Grandview Reserve Phase 1 Traffic Impact Analysis (LSC #S214240) August 12, 2021

LSC Responses to TIS Redline Comments

Figure 8

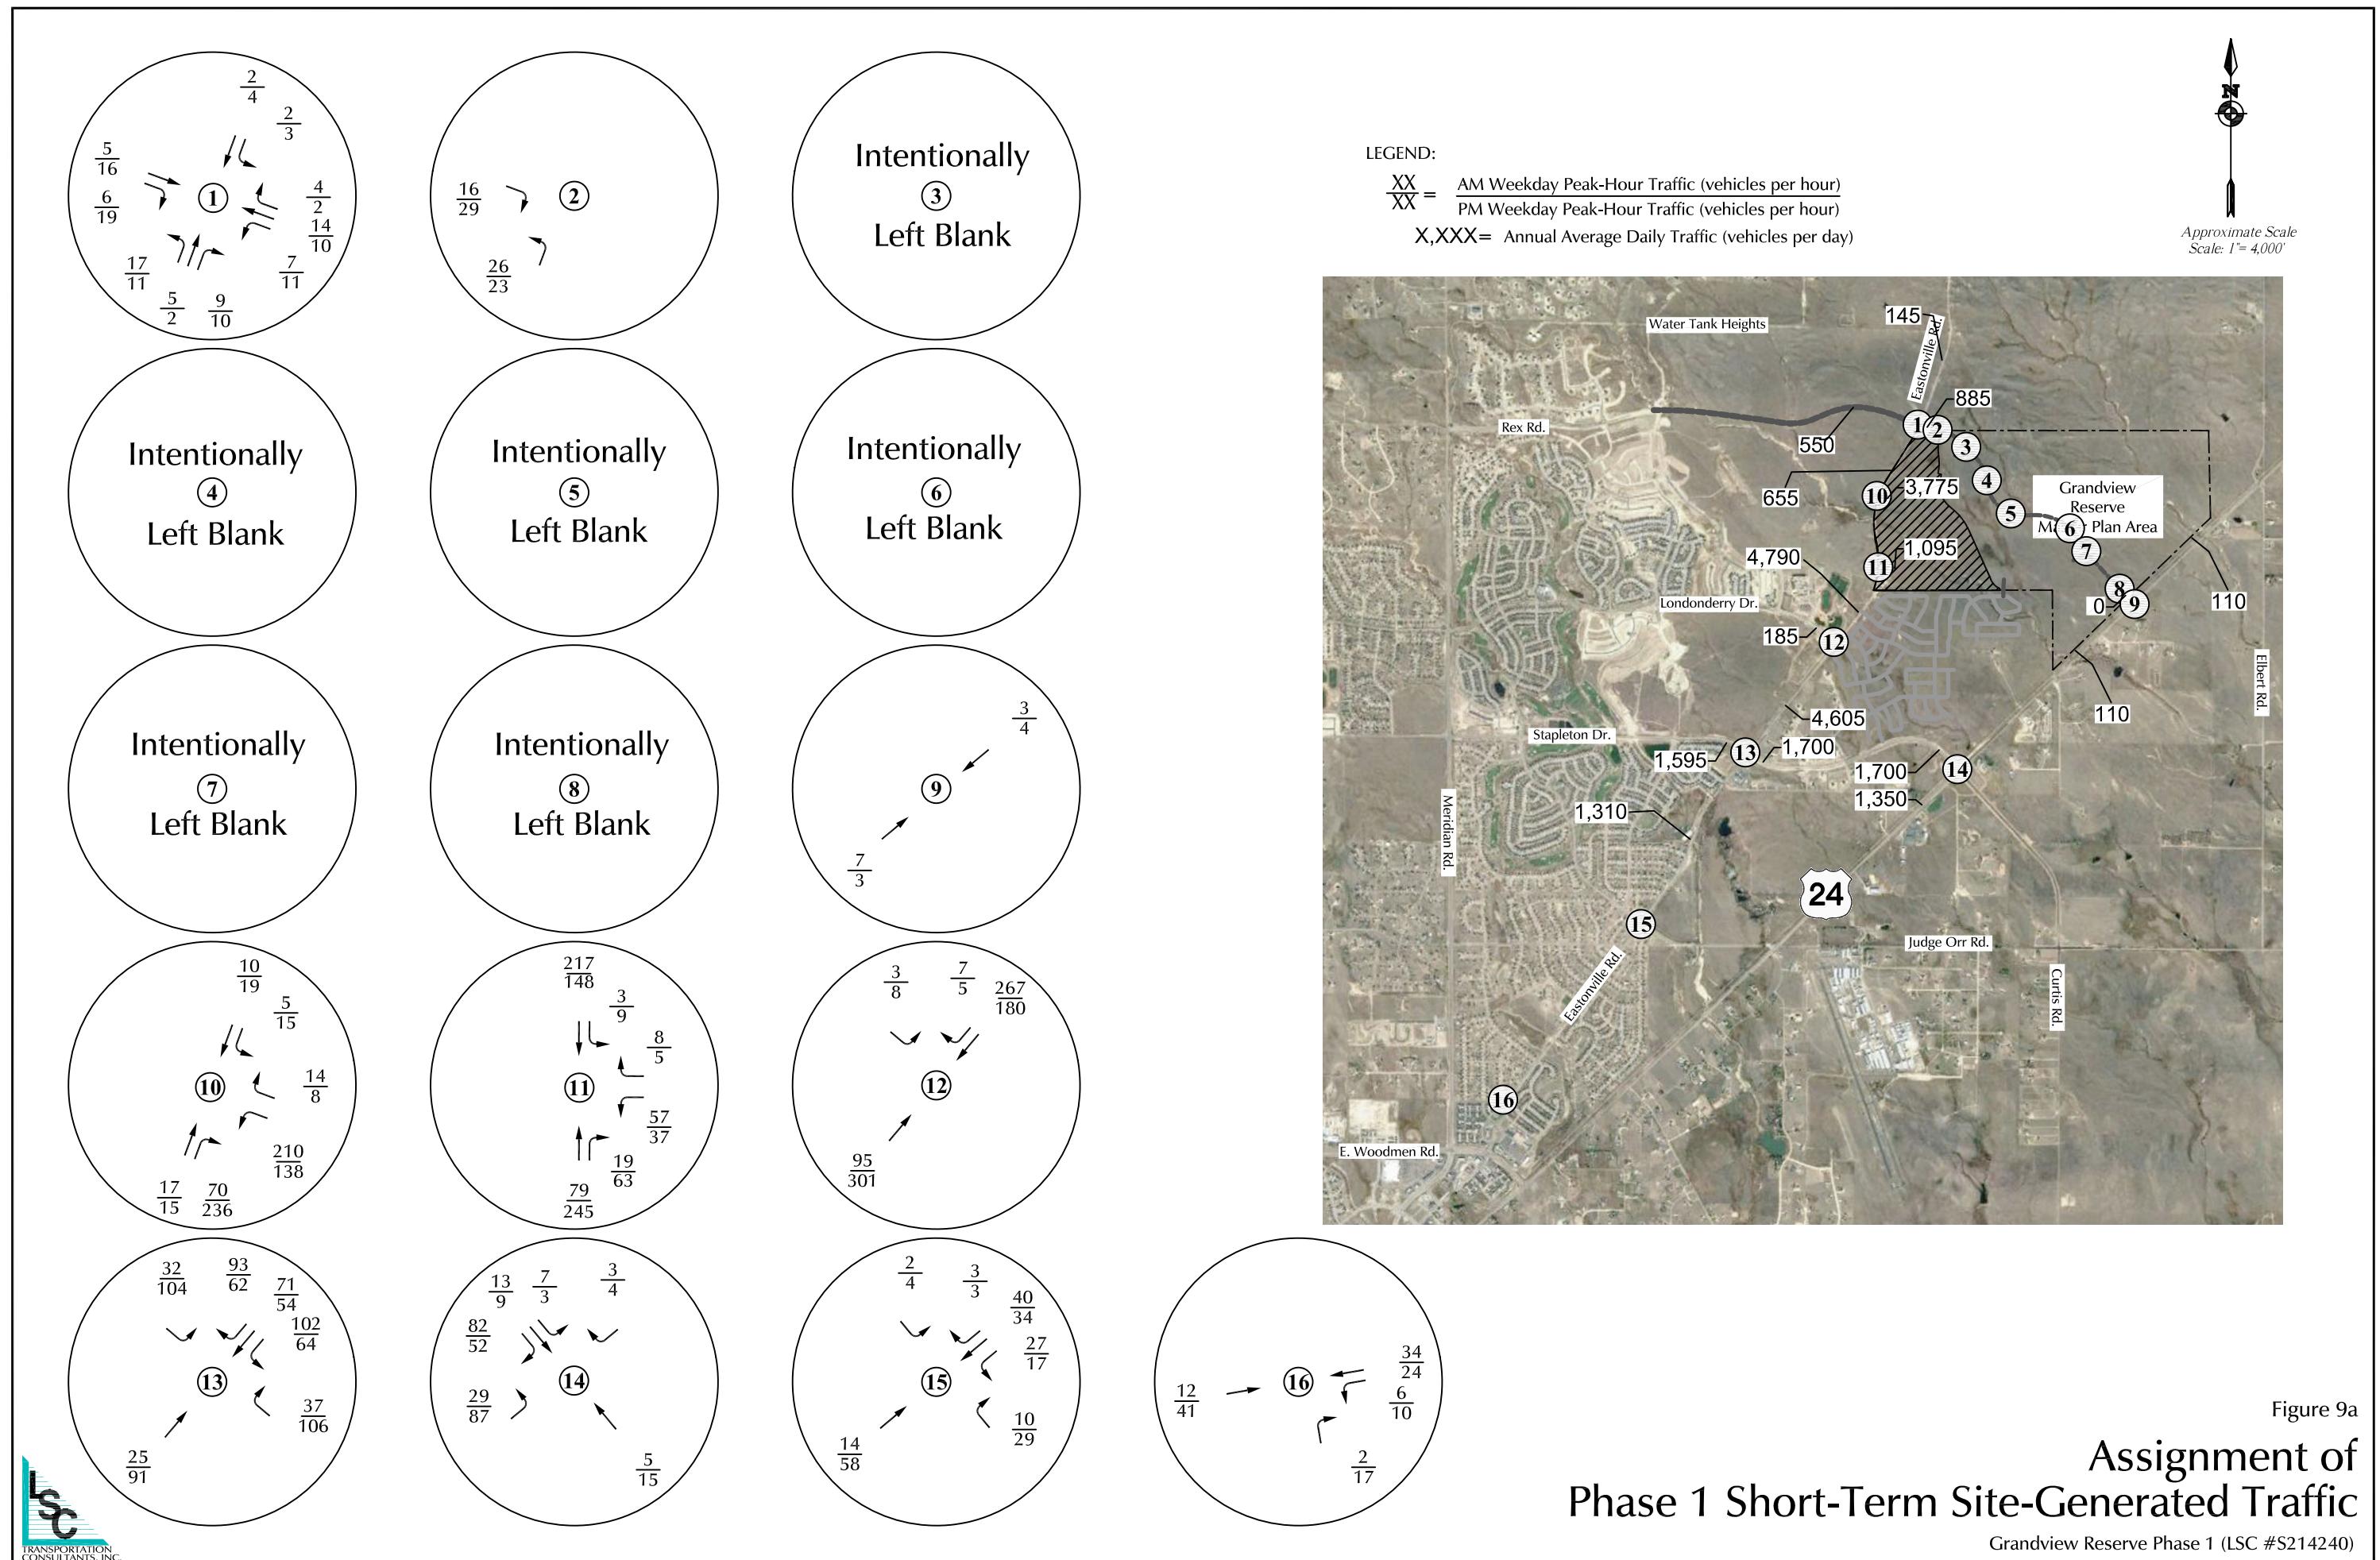
This seems high

Author: kdferrin Subject: Sticky Note Date: 12/10/2021 2:33:24 PM
LSC Response: The directional distribution estimates have been revised.

Figure 11b

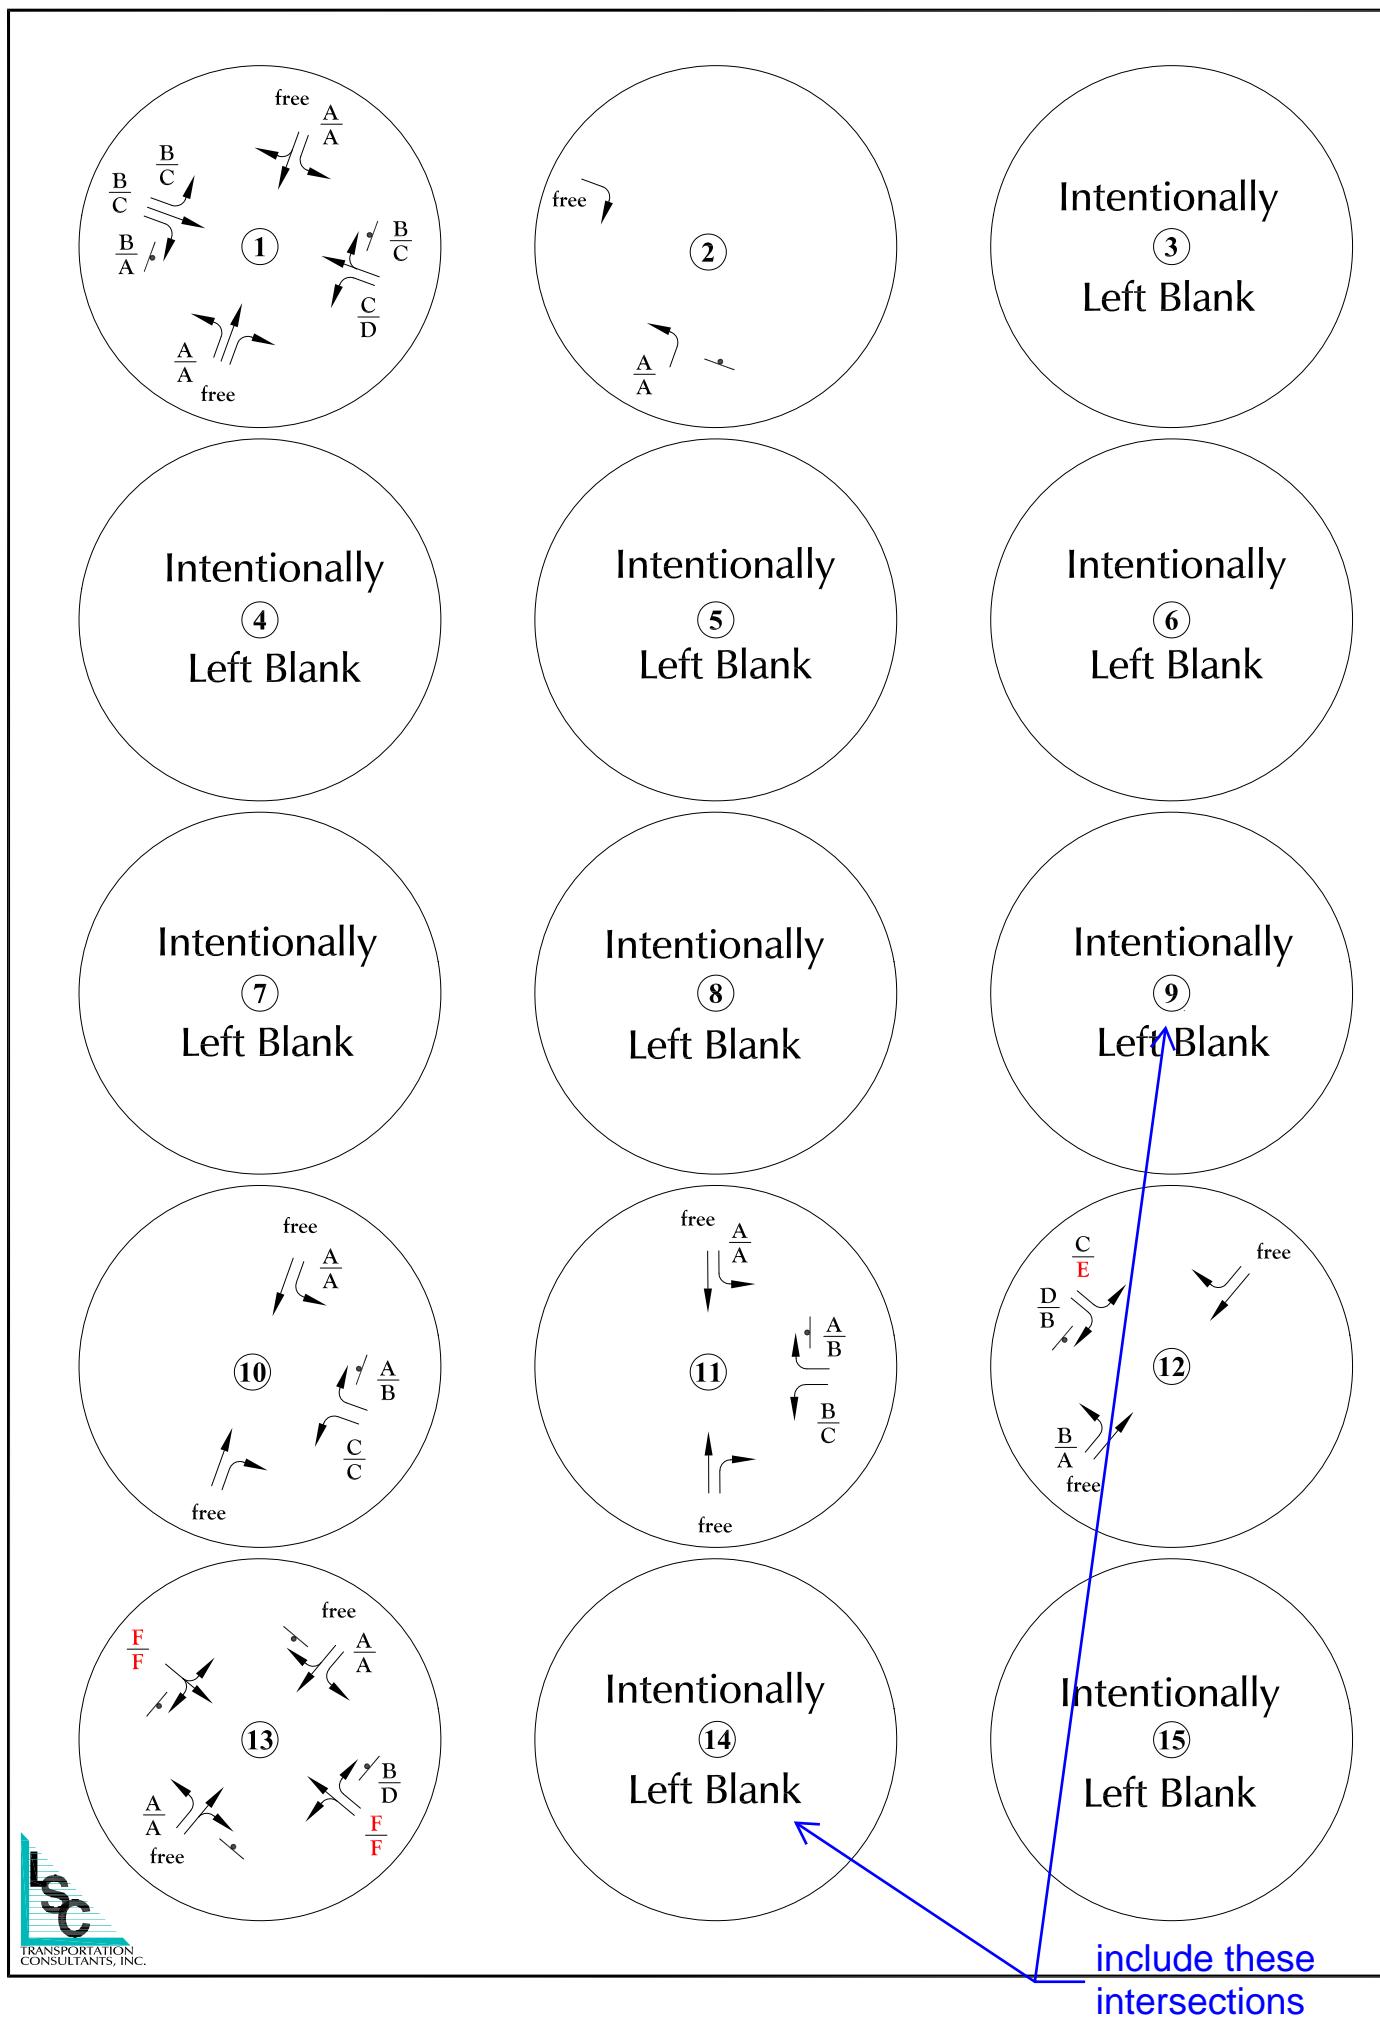
[include these intersections](#)

LSC Response: The intersection of US 24/Stapleton has been included in the updated TIS. Rex/US 24 is not planned to be constructed as part of Phase 1.

Figure 6a
 Year 2041
 Background Traffic
 Grandview Reserve Phase 1 (LSC #S214240)

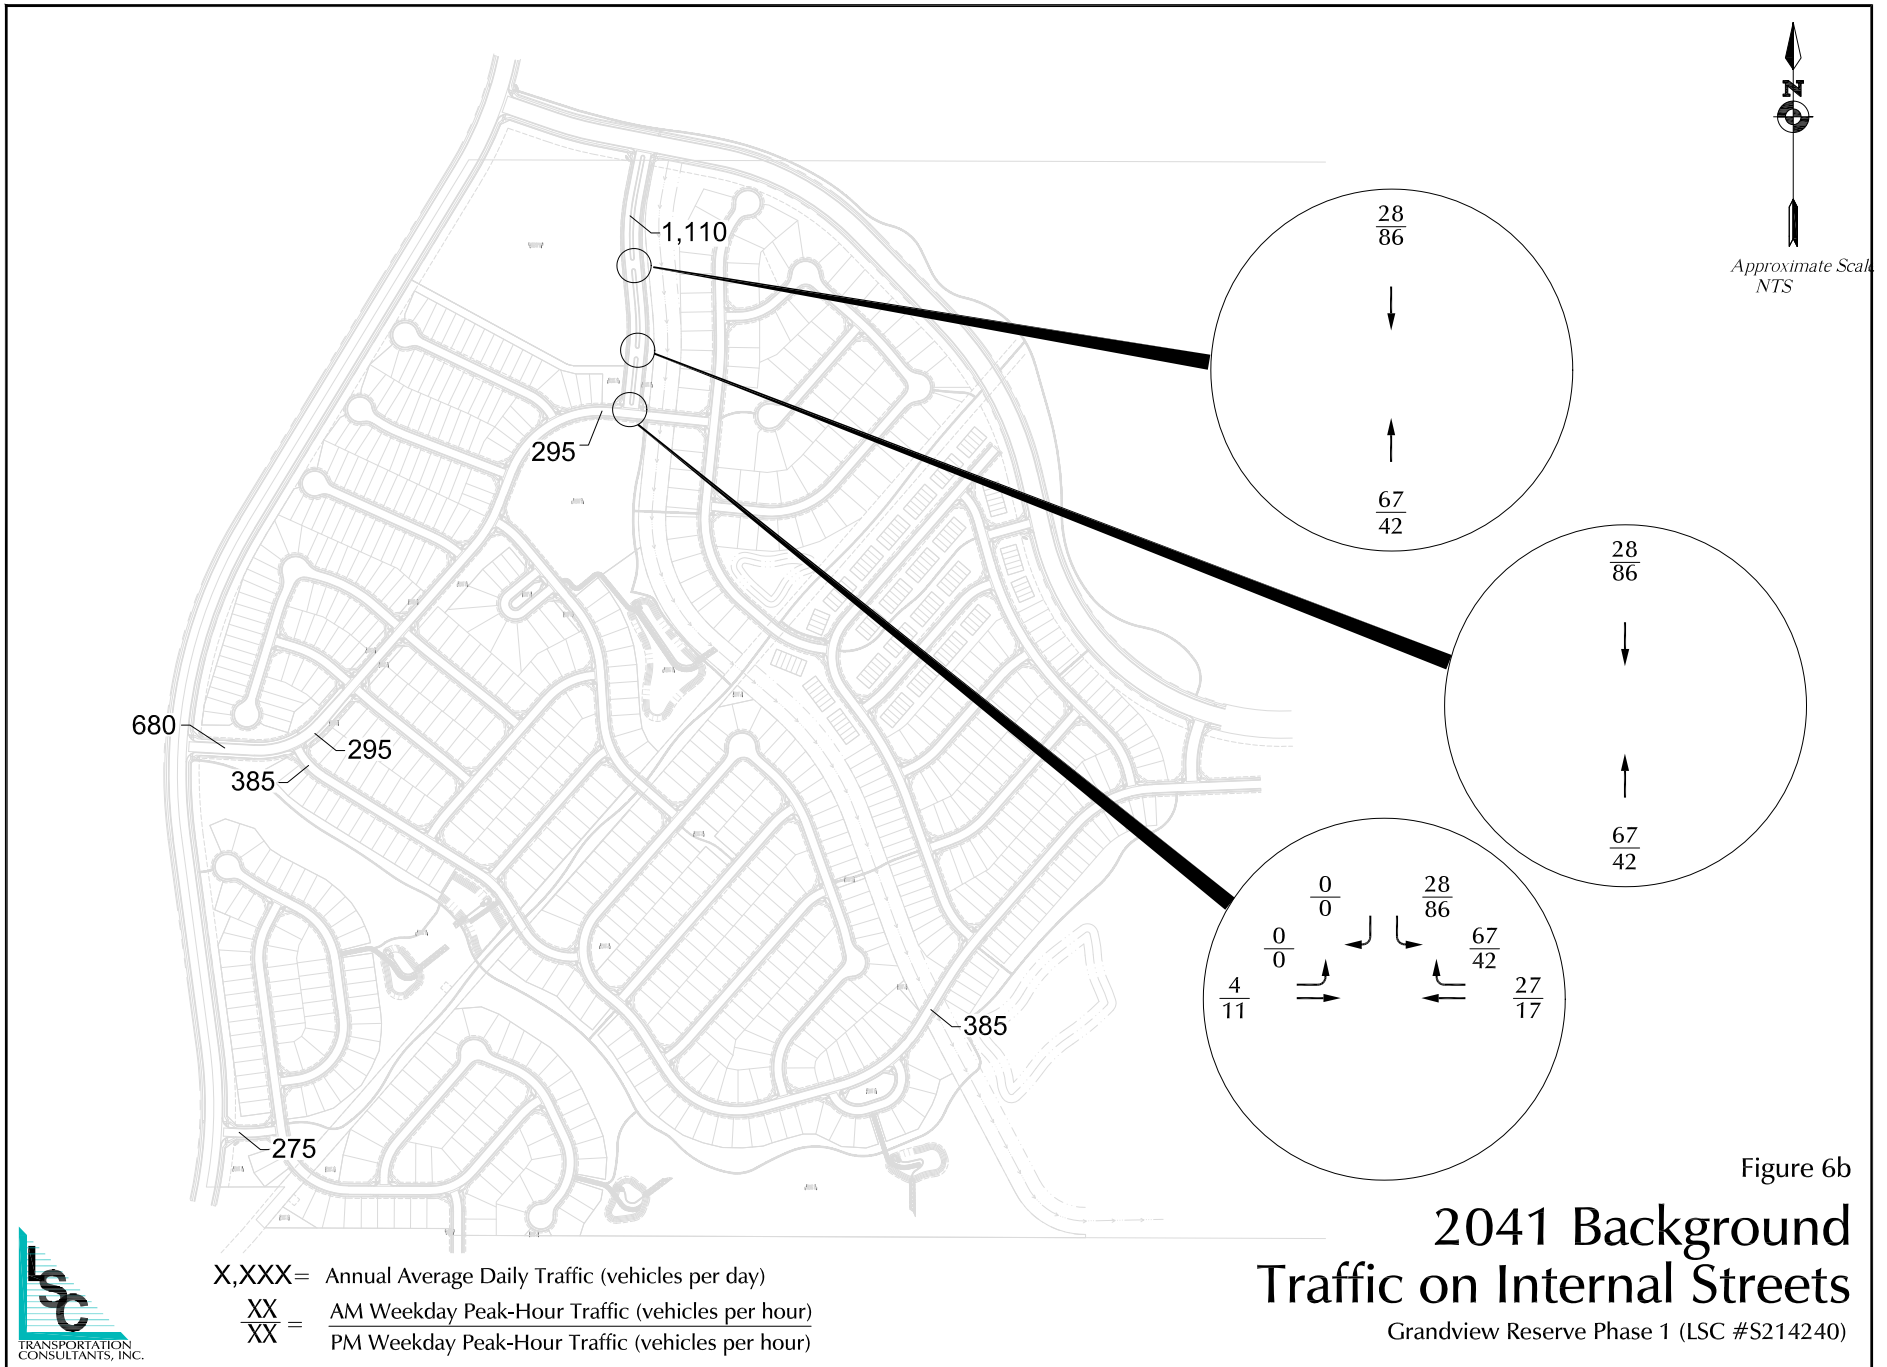
why are these so different than the SKP TIS?

LSC Response: The background traffic in the SKP TIS did not include any Grandview Sketch Plan trips (all those trips were "site traffic" in that report for the entire development). The 2040 Background volumes in this report for the Phase 1 portion include projected traffic from future Grandview Reserve filings. Only phase 1 traffic is "site traffic."
